Current Zoning: R-MH LWPA LLWPA (residential manufactured housing, Lake Wylie Protected Area, Lower Lake Wylie Protected Area)
Proposed Zoning: I-2(CD) LWPA LLWPA (general industrial, Lake Wylie Protected Area, Lower Lake Wylie Protected Area)

Approximately 10.918 acres located on the southern side of John Gladden Road, north of Wilkinson Boulevard, and west of Sam Wilson Road

The petition proposes to rezone site to I-2(CD) to develop the site for off-site parking and outdoor storage.

PLANNING STAFF REVIEW

RZ-1.0

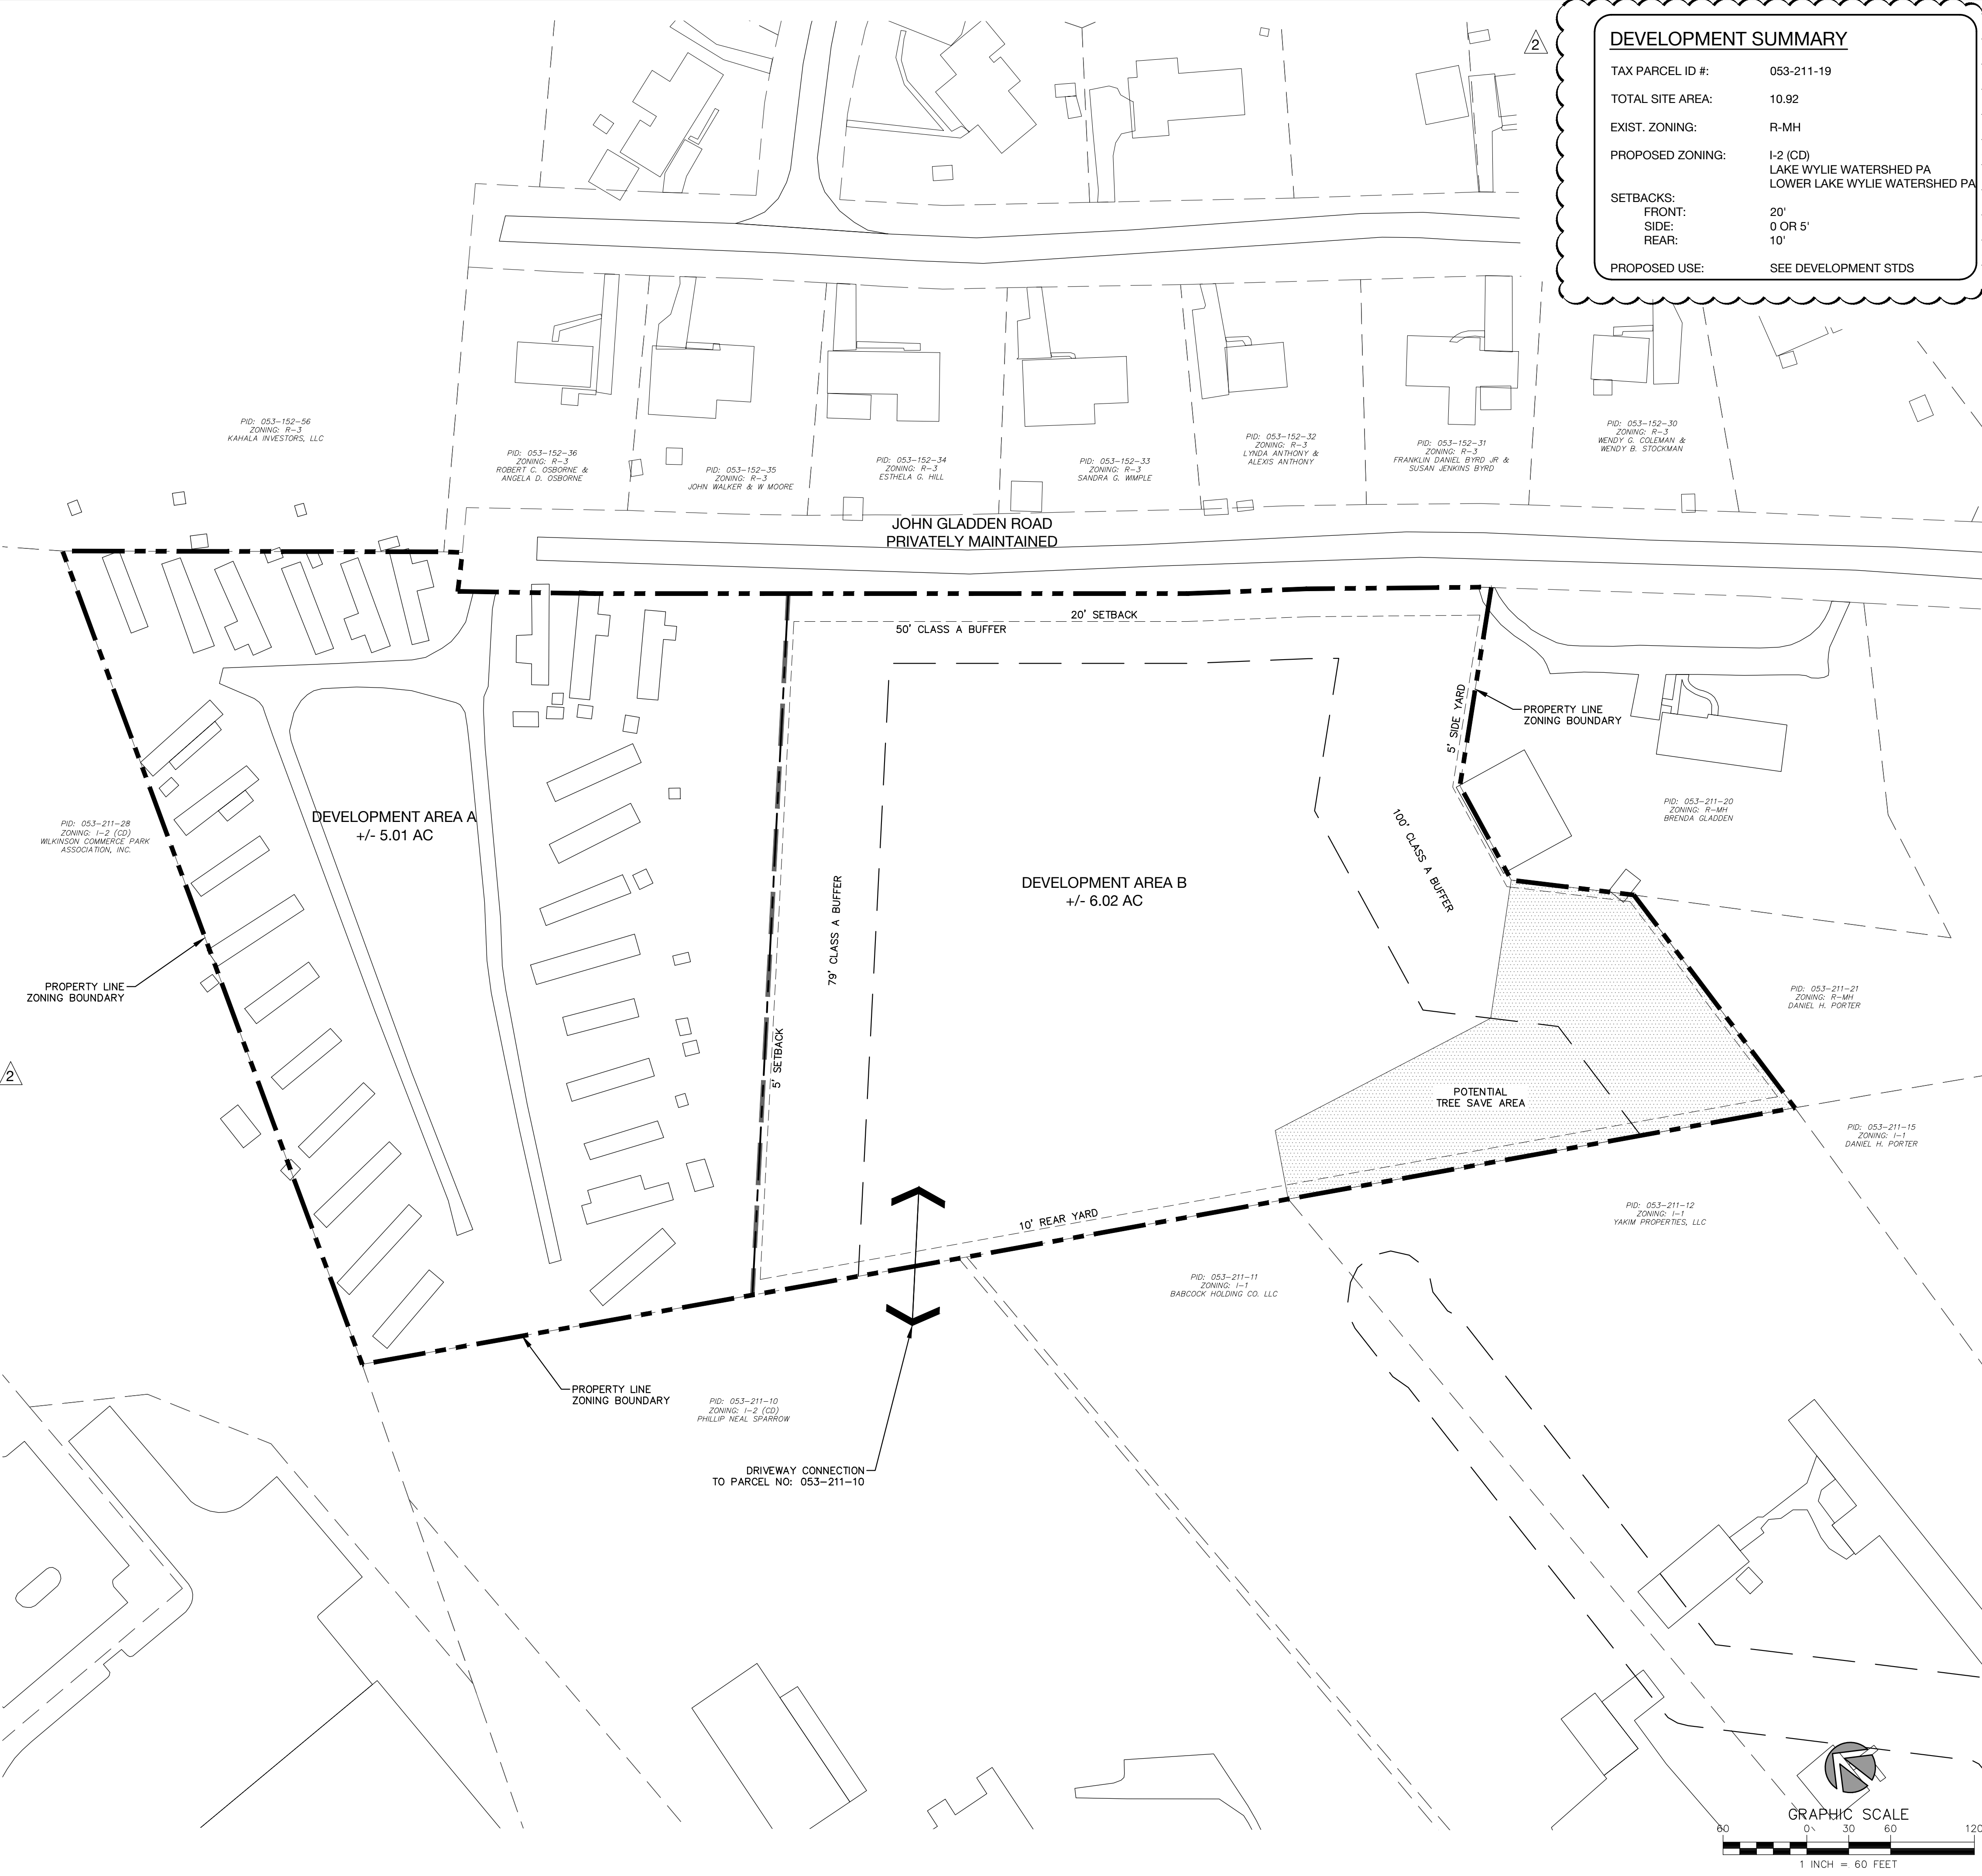
1. Will need to show required future buffer adjacent to R-3 single-family in Development Area A.

2. The petitioner should revise the site plan and conditional notes, in reference to Sections 3.A. and 3.B, to establish and record a cross access easement across Tax Parcel Nos. 053-211-07 and 053-211-10 to Wilkinson Boulevard. Access agreement for all three parcels in the event that one or more parcel(s) is sold to another individual/entity for access to be maintained to Wilkinson.
